KIRKLEES METROPOLITAN COUNCIL INVESTMENT & REGENERATION SERVICE

DELEGATED DECISION TO DETERMINE APPLICATIONS FOR LISTED BUILDING CONSENT

Reference No:	2025/44/92476/W
Site Address:	Queensgate Market, Princess Alexandra Walk, Huddersfield, HD1 2UJ
Description:	Discharge of details reserved by conditions 14 (blinds), 15 (flooring), 17 (market stalls), 19 (partition wall/glazed screen) on previous permission 2024/90270 for Listed Building Consent for demolition, alteration, refurbishment and extension to create library, food hall and public realm (part within a Conservation Area)
Recommending Officer:	Katie Chew

Application: 2025/92476

DRAWING TITLE
Joinery Details
Coat of Arms Display Case

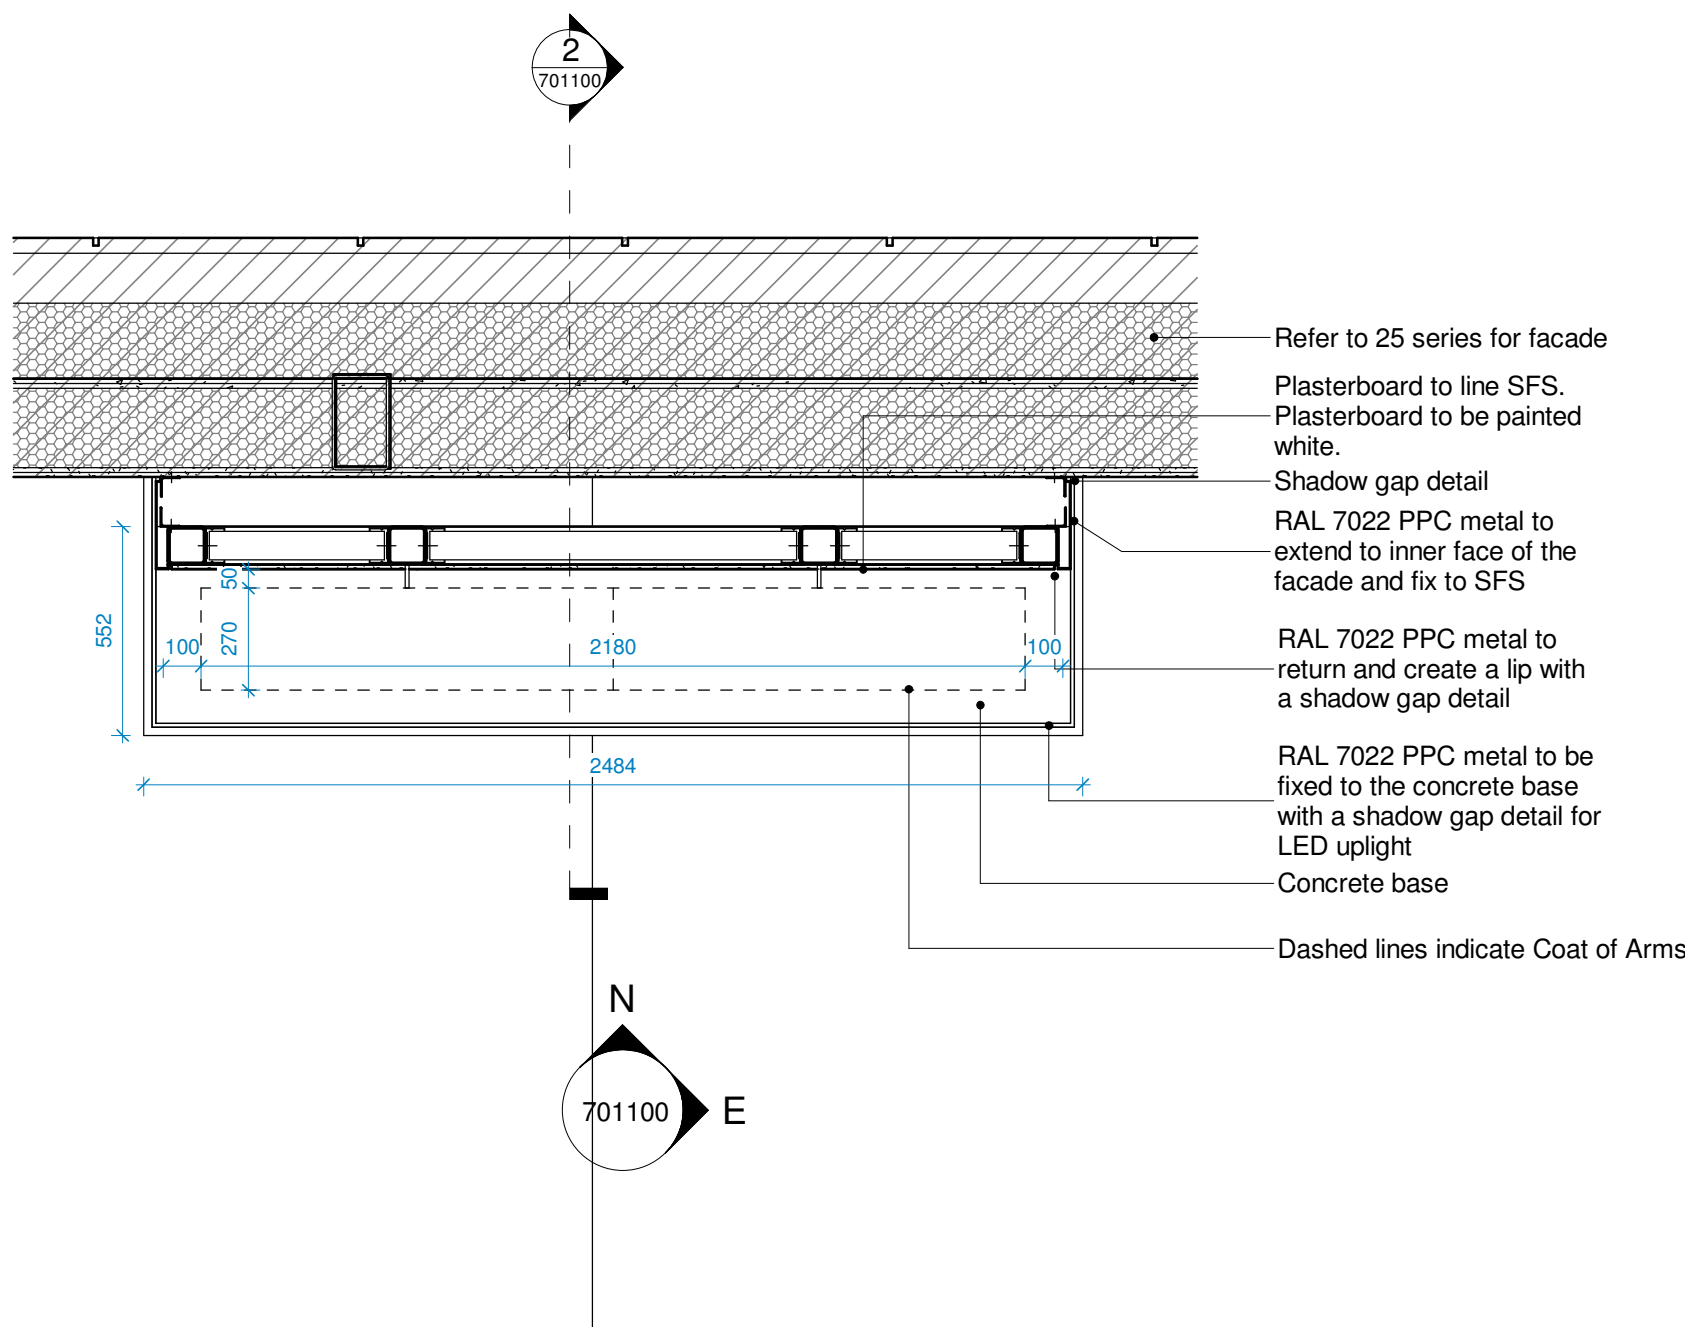
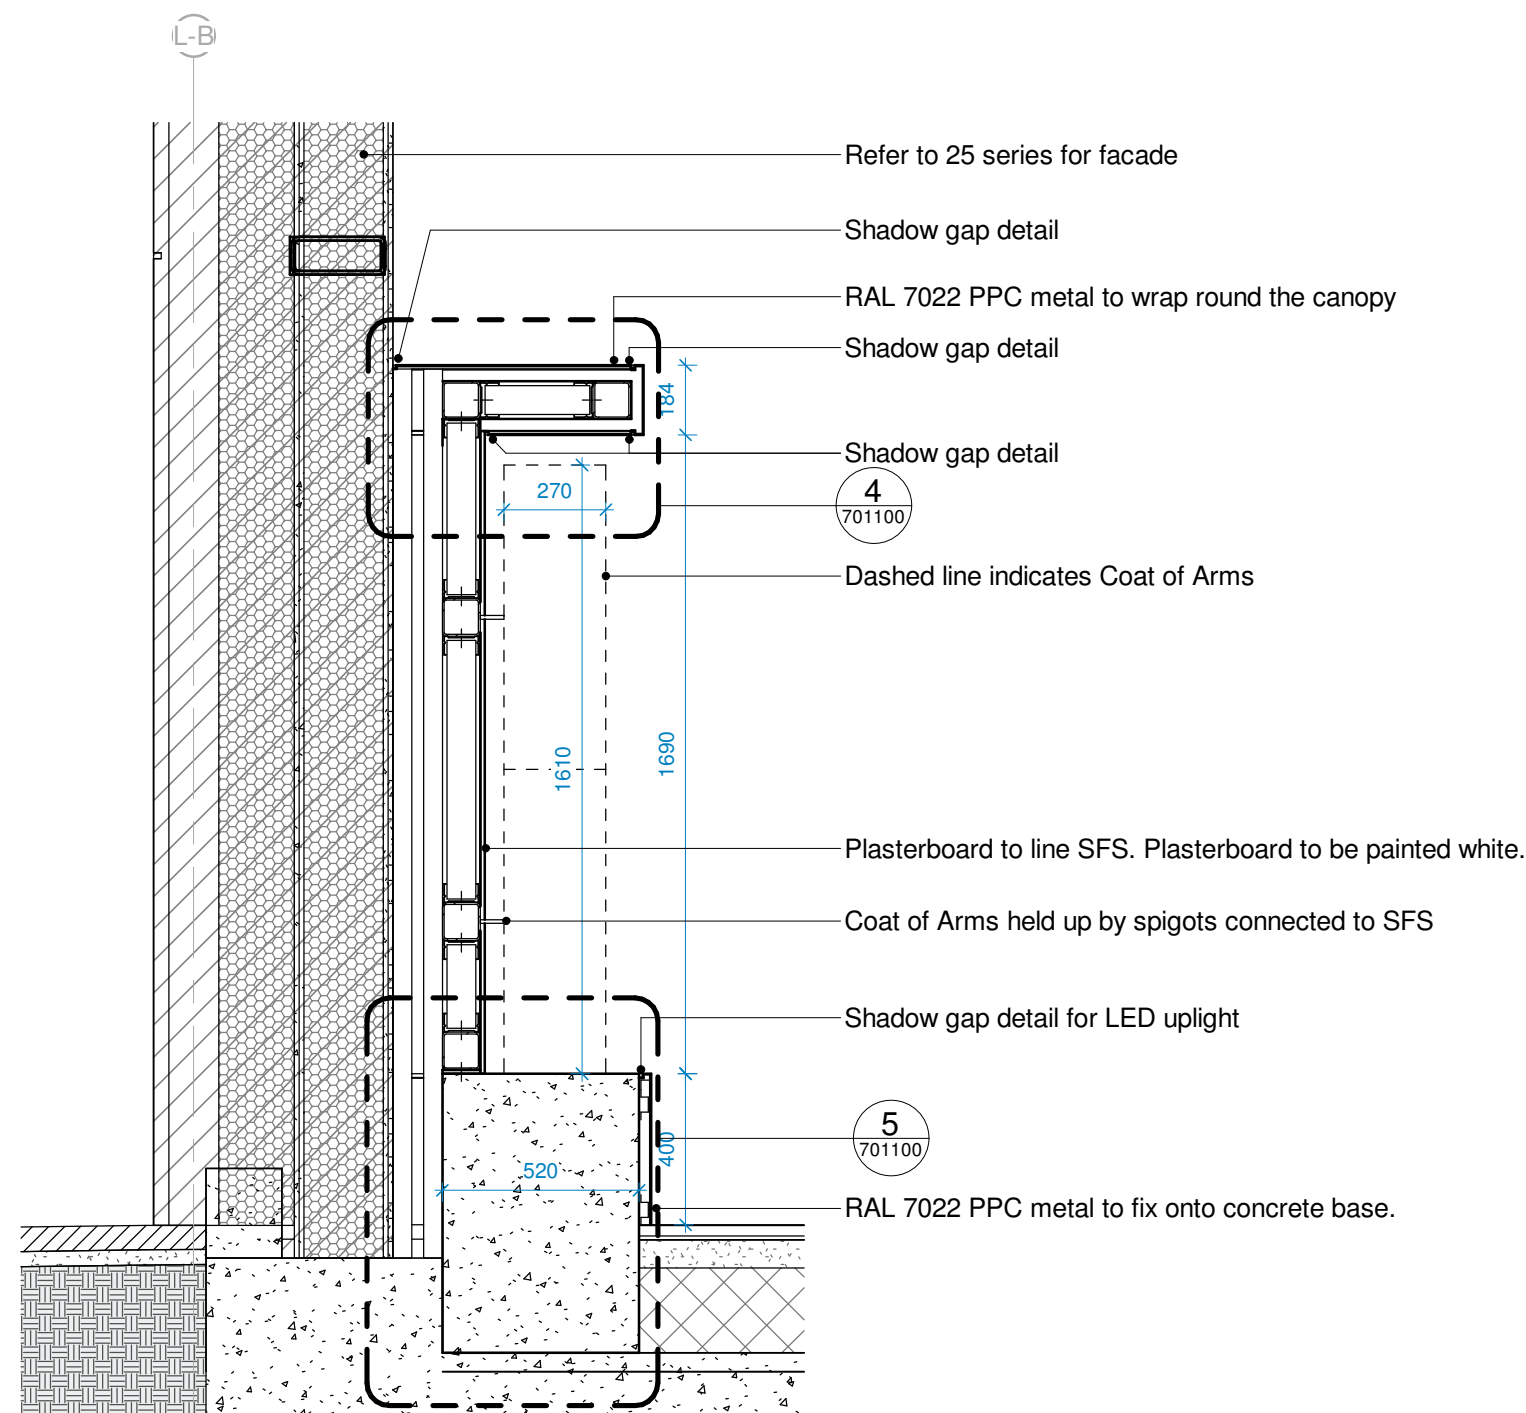
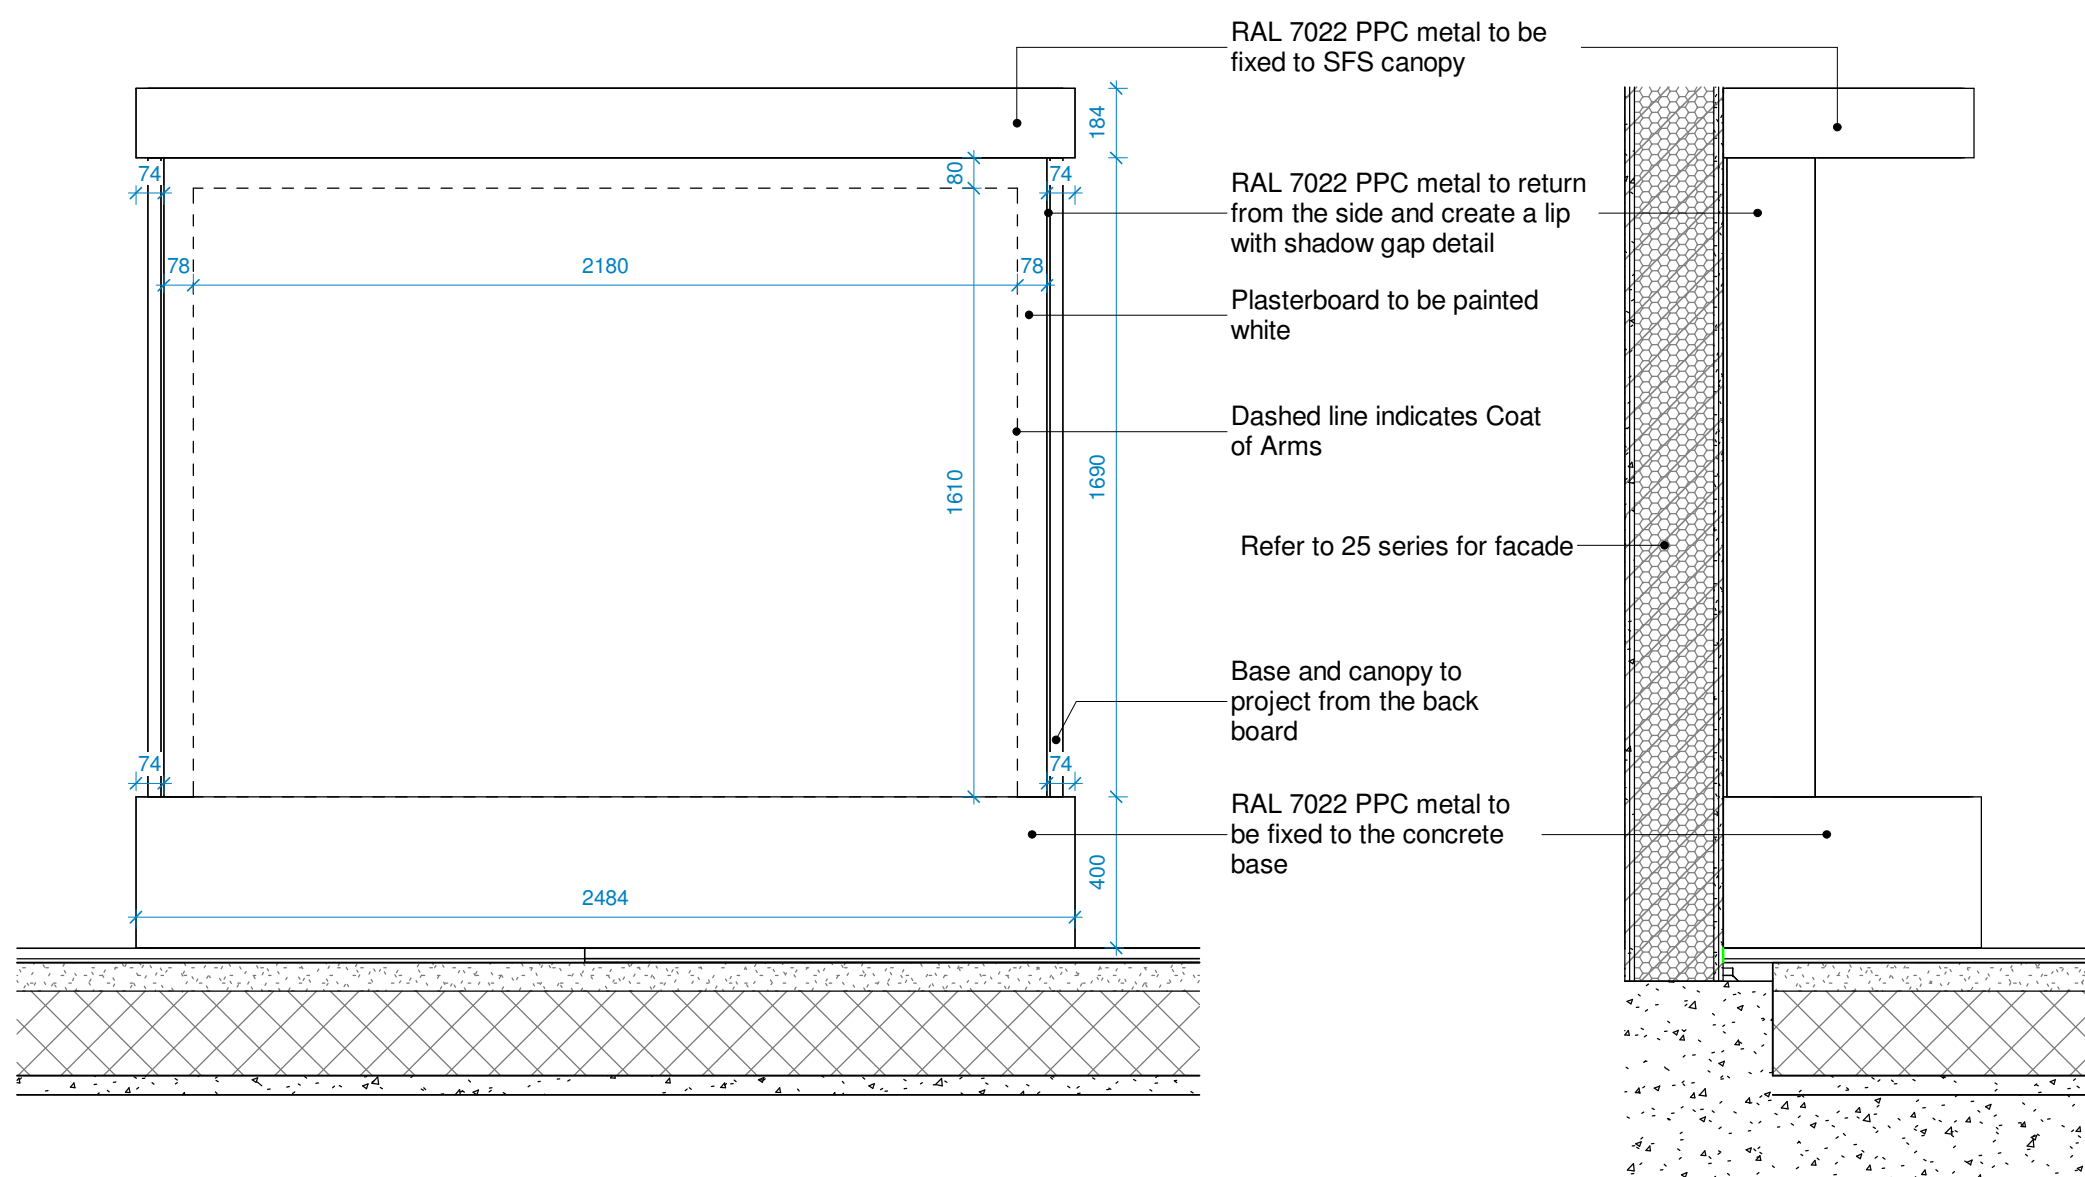
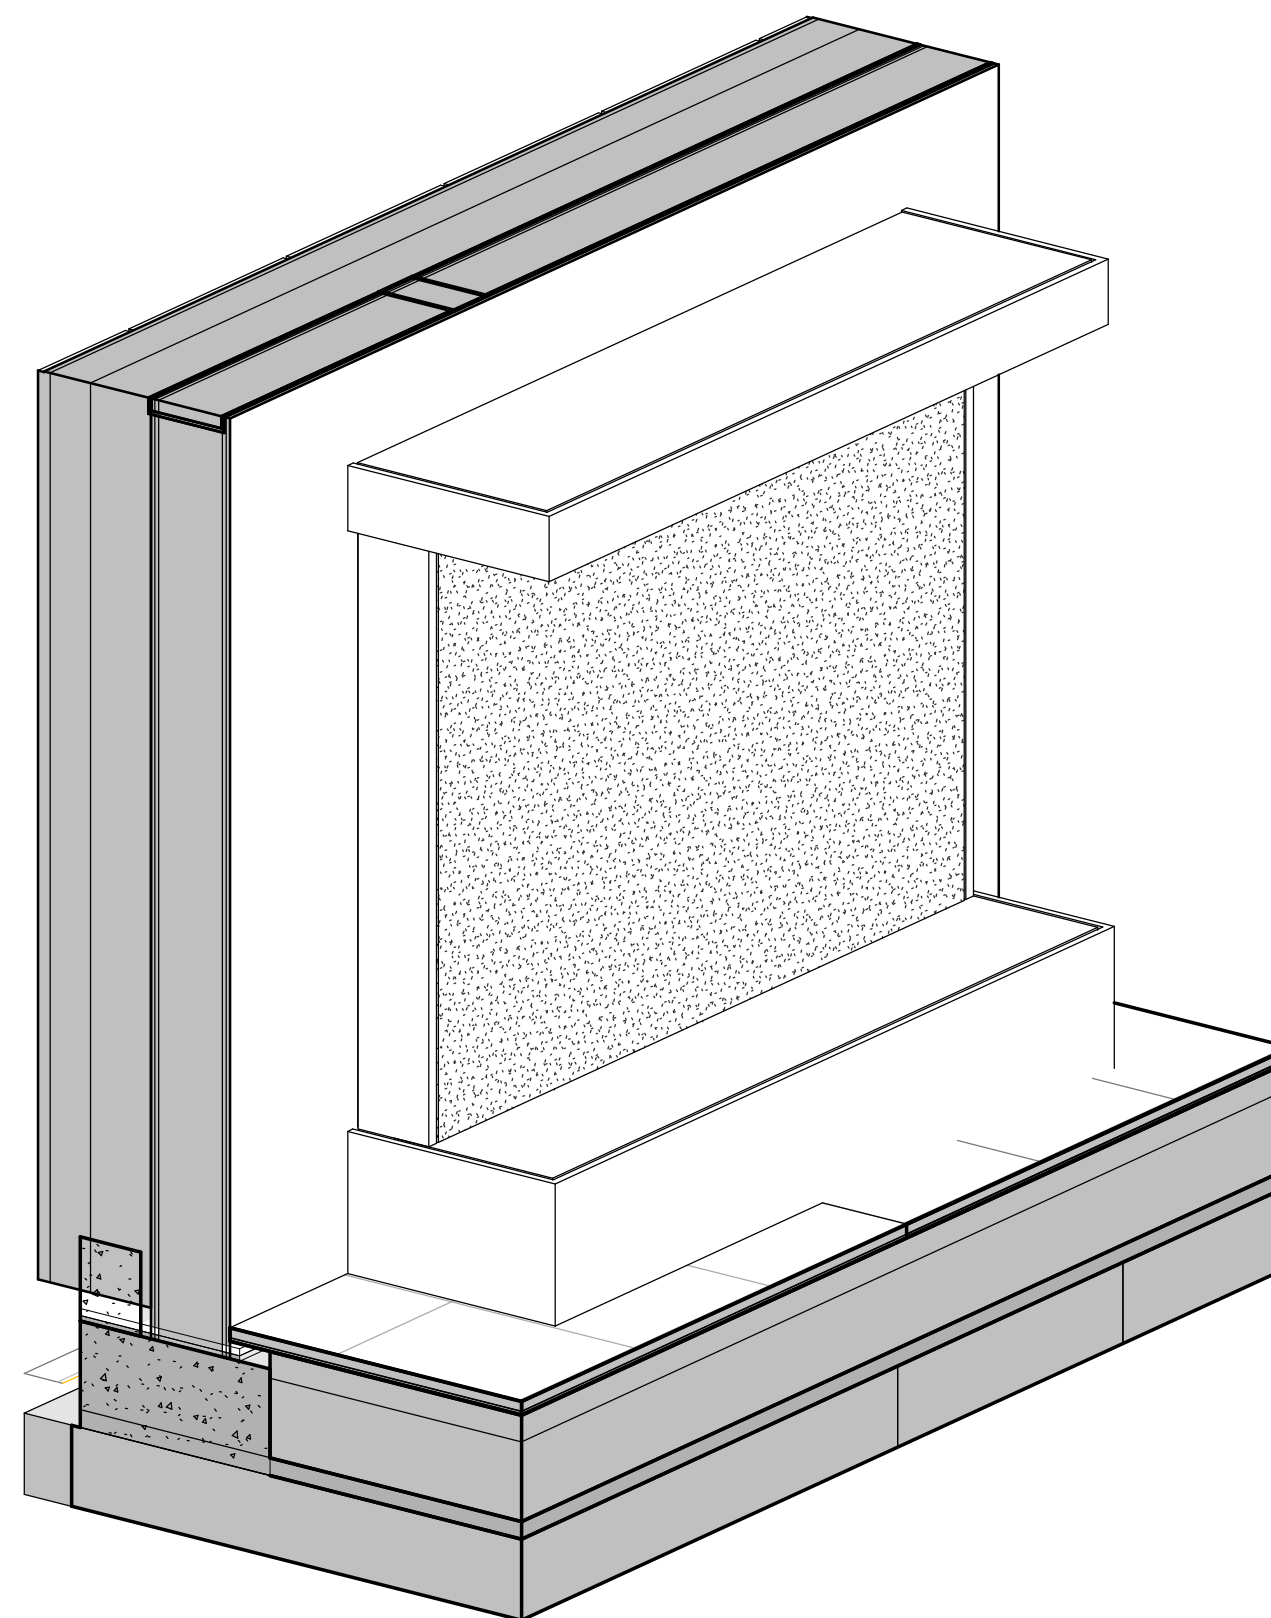
17. The retained market stalls refers to some retained terrazzo upstand panels that will be refixed to the rear entrance as shown on the following drawing. The location and reason for this was explained at a site visit on 25th July 2025. [Conservation & Design Officers] had previously intended that they should be reused in the new food halls, so the proposal is to fix them to the dividing wall at the rear entrance of the food hall.

Officers concur with the conclusions made by KC Conservation & Design and therefore recommend that Condition 17 is approved. However, Condition 17 has the following ongoing requirement, which must be adhered to, to ensure the ongoing compliance of the condition:
